From: Paul Cann <Paul.Cann@arun.gov.uk>
Sent: 09 June 2020 09:54
To: Planning.Responses <Planning.Responses@arun.gov.uk>
Cc: Anita Gardner <Anita.Gardner@arun.gov.uk>; Sarah Burrow <Sarah.Burrow@arun.gov.uk>; John Hall
[REDACTED]
Subject: RE: Planning Consultation on F/9/20/DOC

Engineers comments in respect to surface water drainage and land drainage below. Please note these comments also relate to relevant conditions on F/6/20/DOC, but since they are all related, the comments have been amalgamated together.

APPLICATION NO: F/9/20/DOC

Description of Works: Approval of details reserved by condition imposed under ref F/30/18/PL relating to Condition No 3 - surface water drainage.

TYPICAL SECTION SHOWING SWALE 1 PROFILE

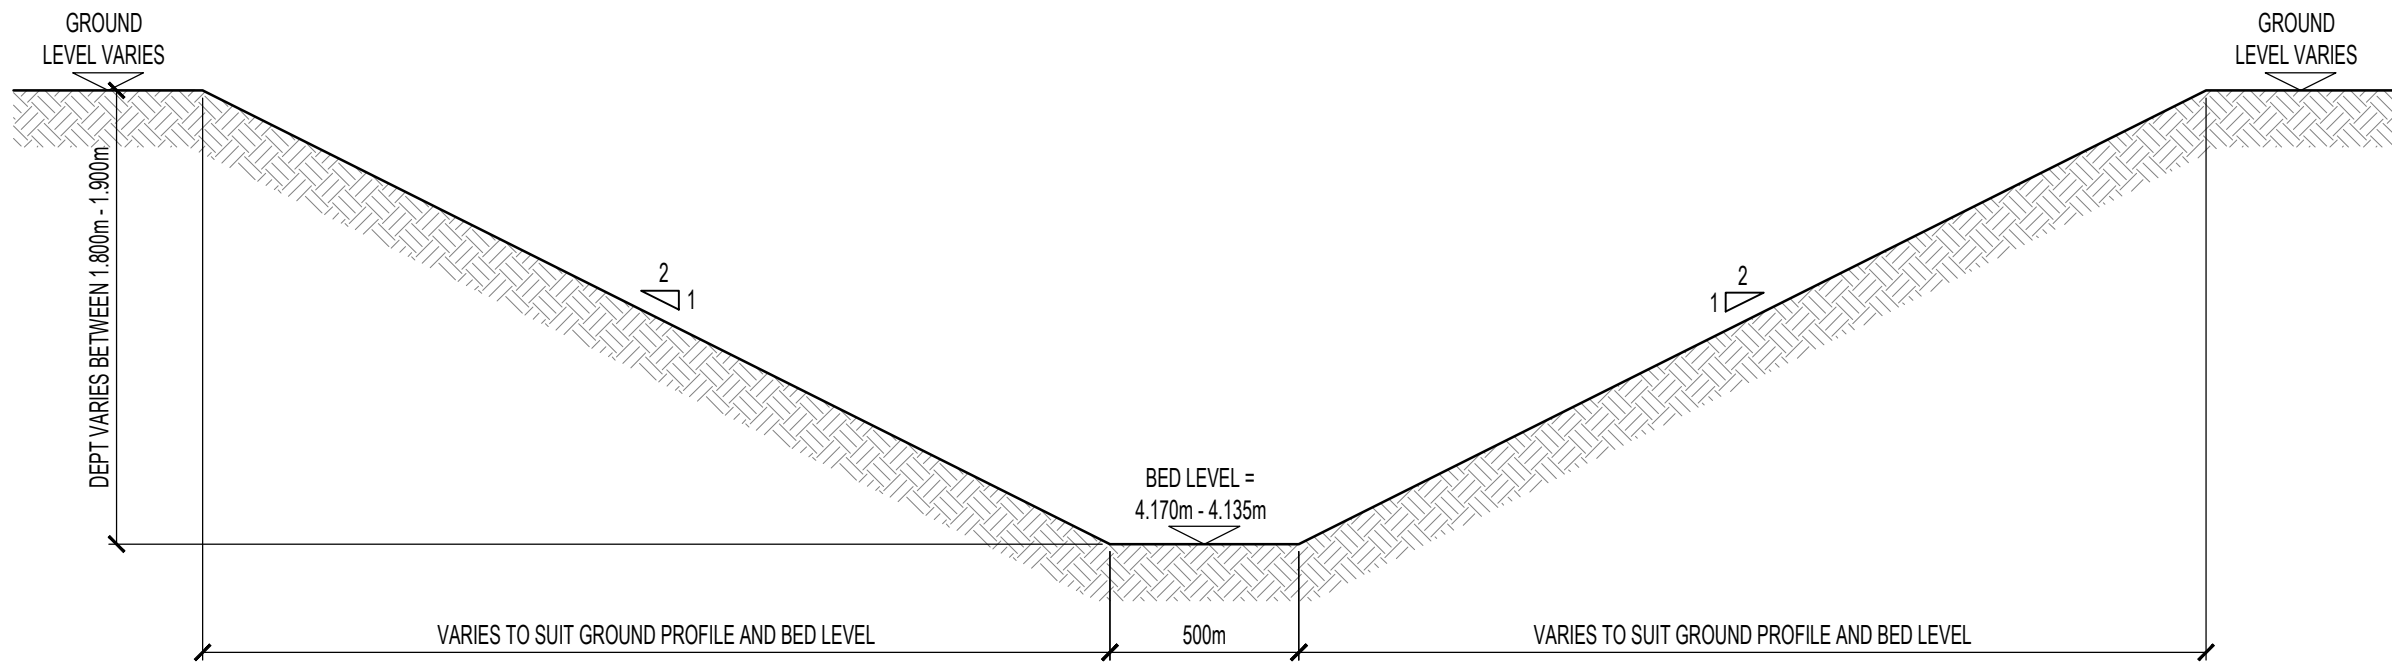
21. Outlets to swale 1 – provide min. 100mm freeboard between swale bed and pipe inverts.
22. Provide positive fall on pond 1 (swale) bed.
23. All pipes to connect soffit to soffit unless otherwise specified – add note.

TYPICAL SECTION SHOWING SWALE 2 PROFILE

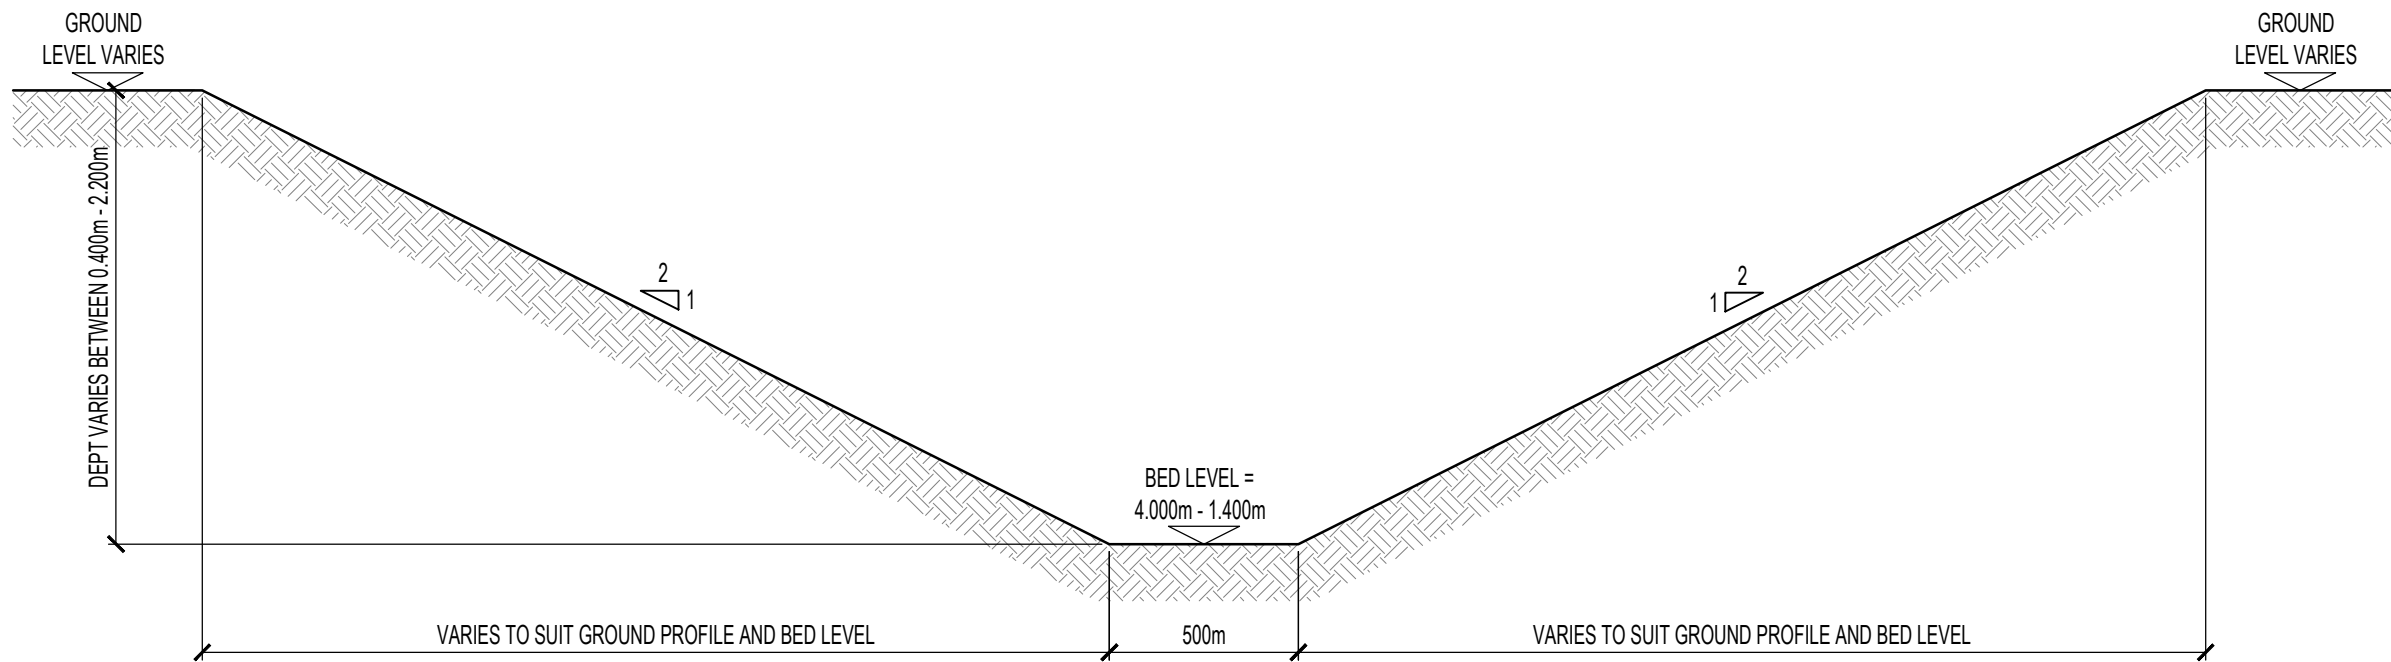
16. Incoming 225mm pipe to swale 2 – provide min. 100mm freeboard between swale bed and pipe invert.
17. Pipe concrete bed and surround detail – specify the specific concrete mix on the detail itself.

TYPICAL SECTION SHOWING POND 1 PROFILE

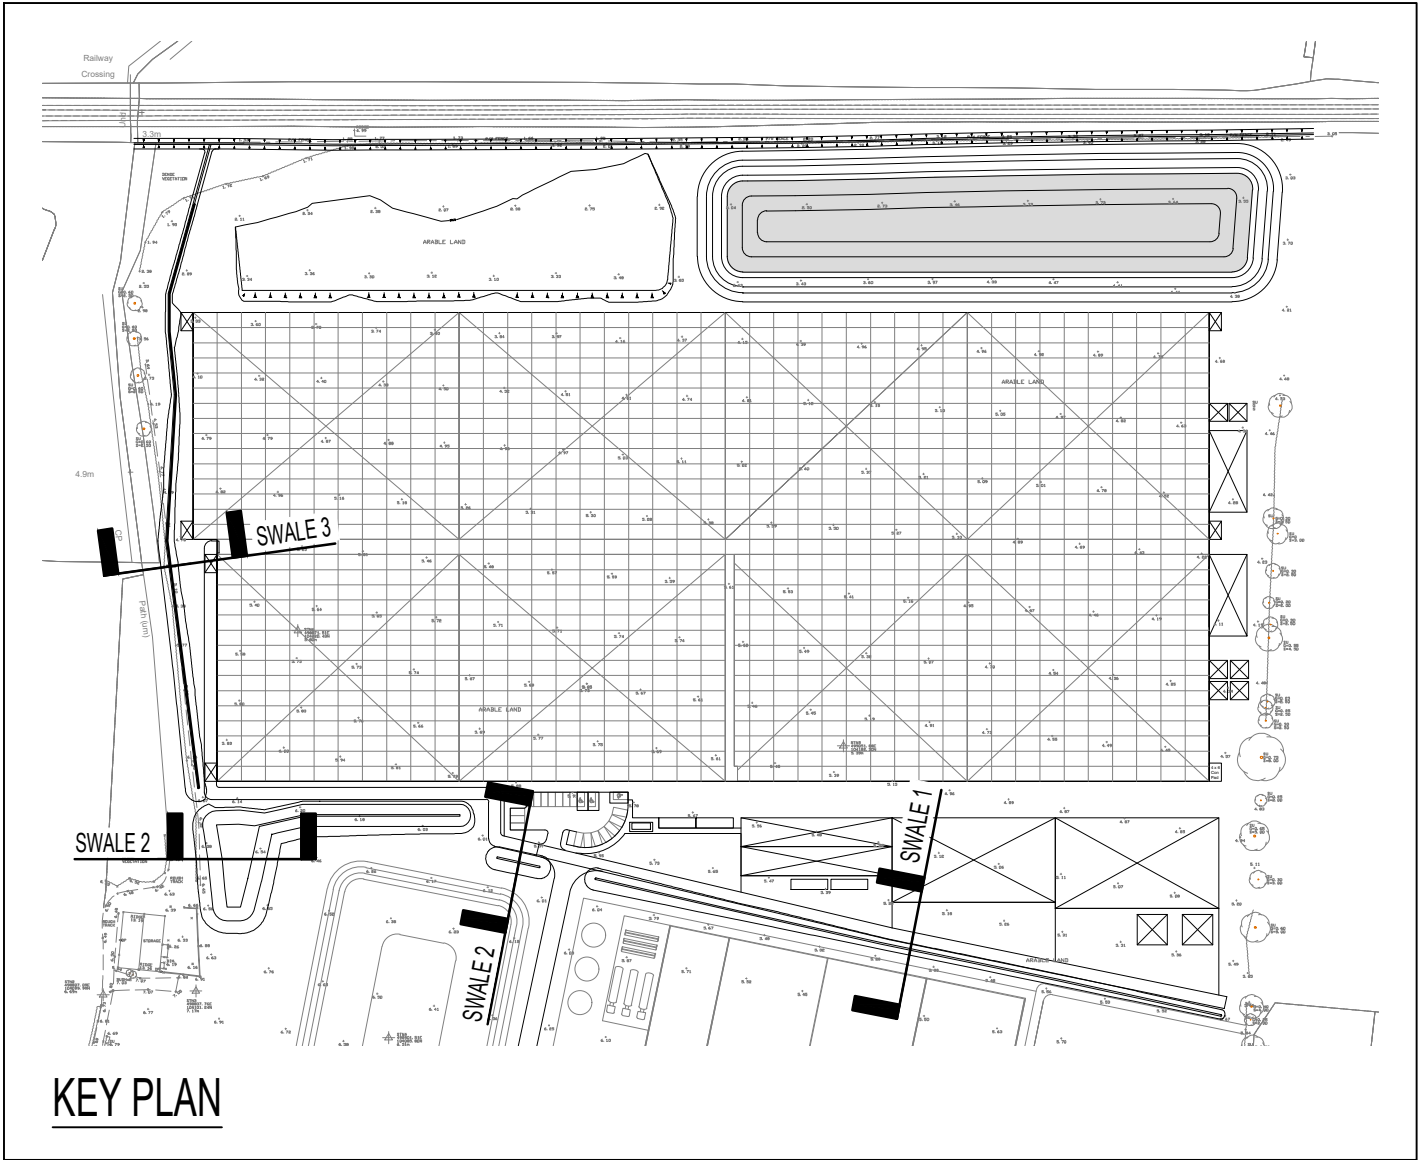
26. Pond 1 and associated swales – show top of bank levels on all sides.
27. Provide causeway flow calculations for reservoir system. The CEP calculations provided were only preliminary and do not reflect the actual design.

PRIVATE MANHOLE DETAIL TYPE W (WITH CATCHPIT)
DEPTH FROM COVER LEVEL TO SOFFIT OF PIPE 1.0m - 1.5m
INTERNAL CHAMBER DIAMETER 1500mm*
MAX. SEWER DIAMETER 375mm
(SCALE 1:25)

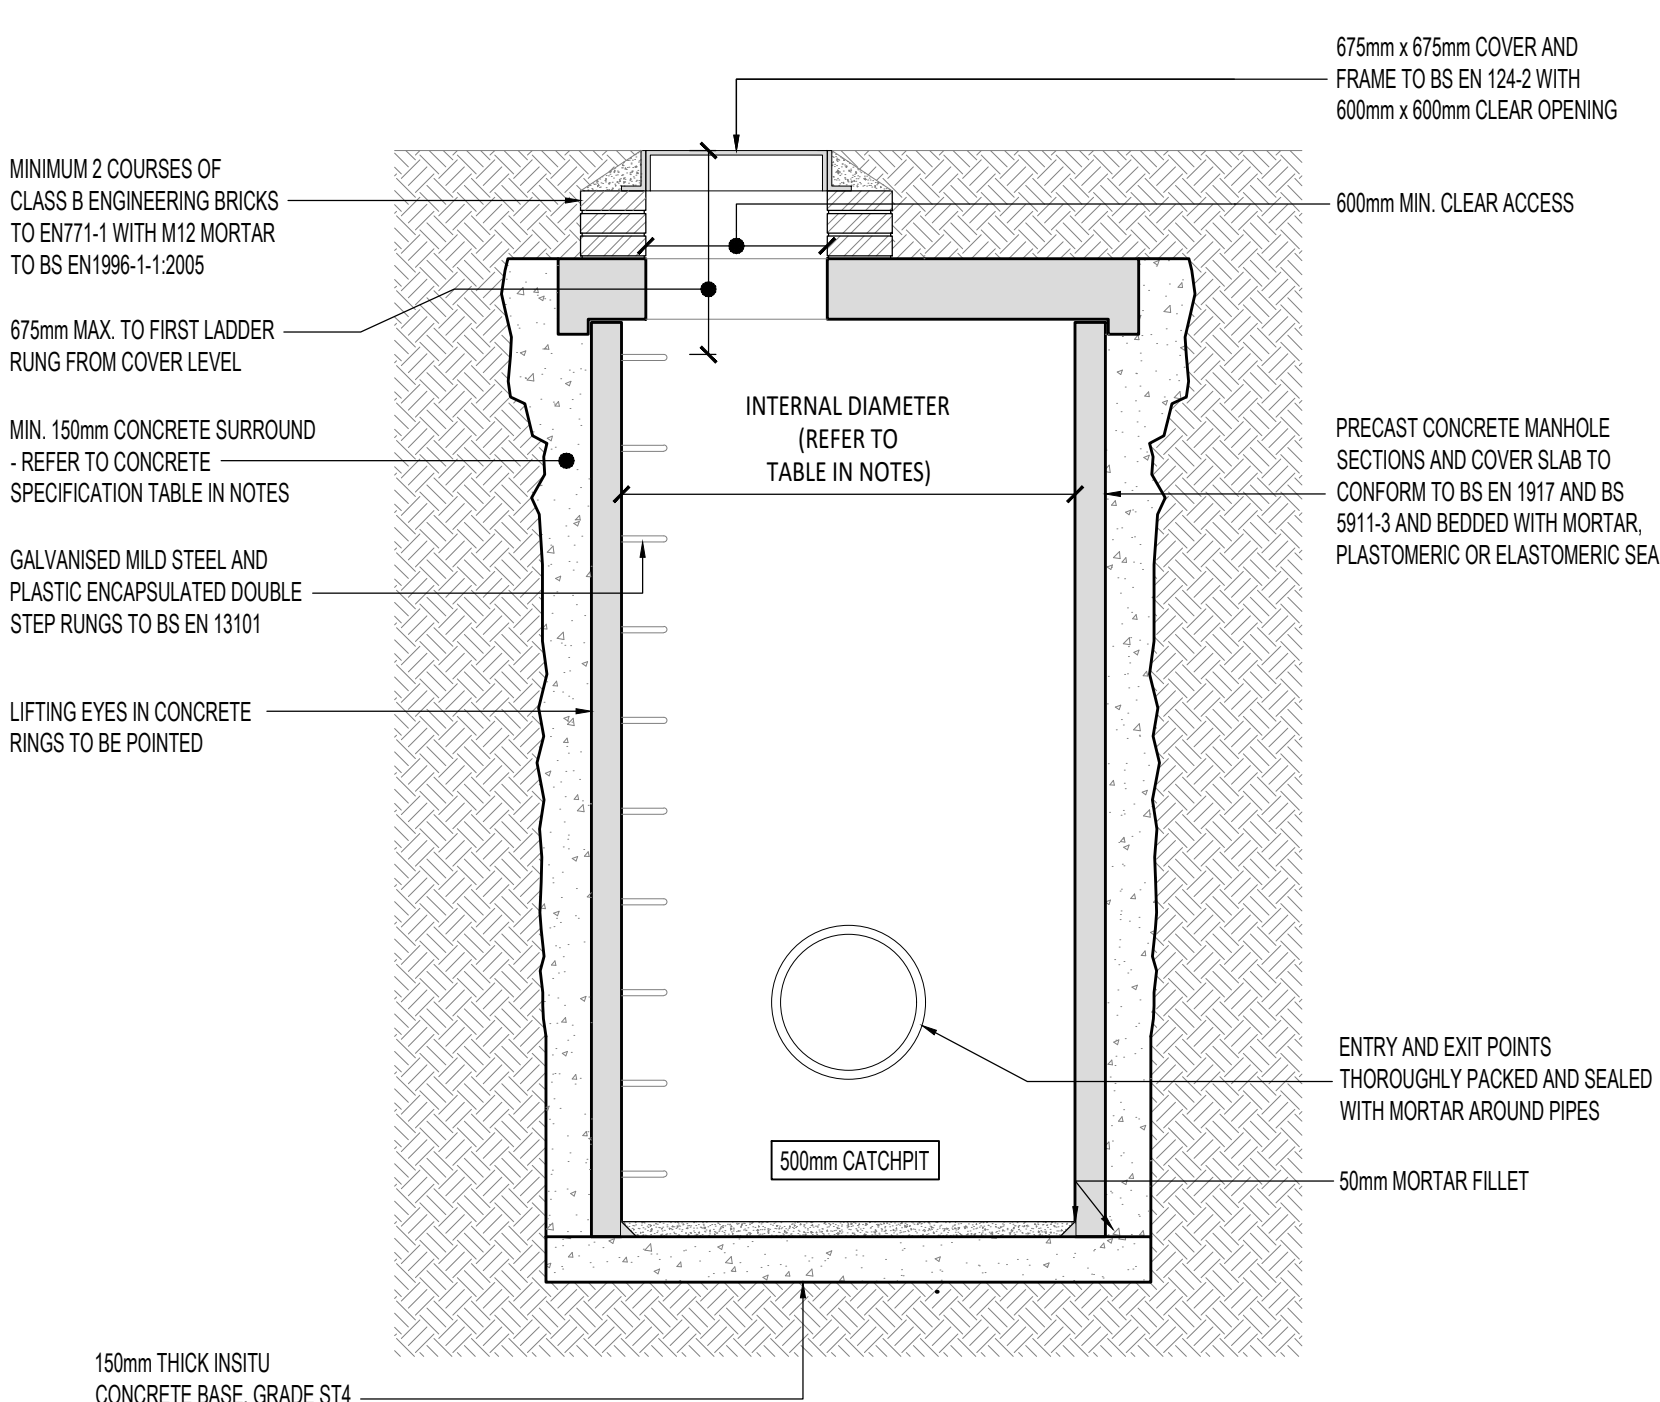
12. Catchpit type W detail – include step rungs for access.
13. Reservoir outlet is at very steep gradient and connecting at 90 degrees to the hydrobrake. Resultant flows could affect the performance of the hydrobrake – could this arrangement be revised to improve the situation.
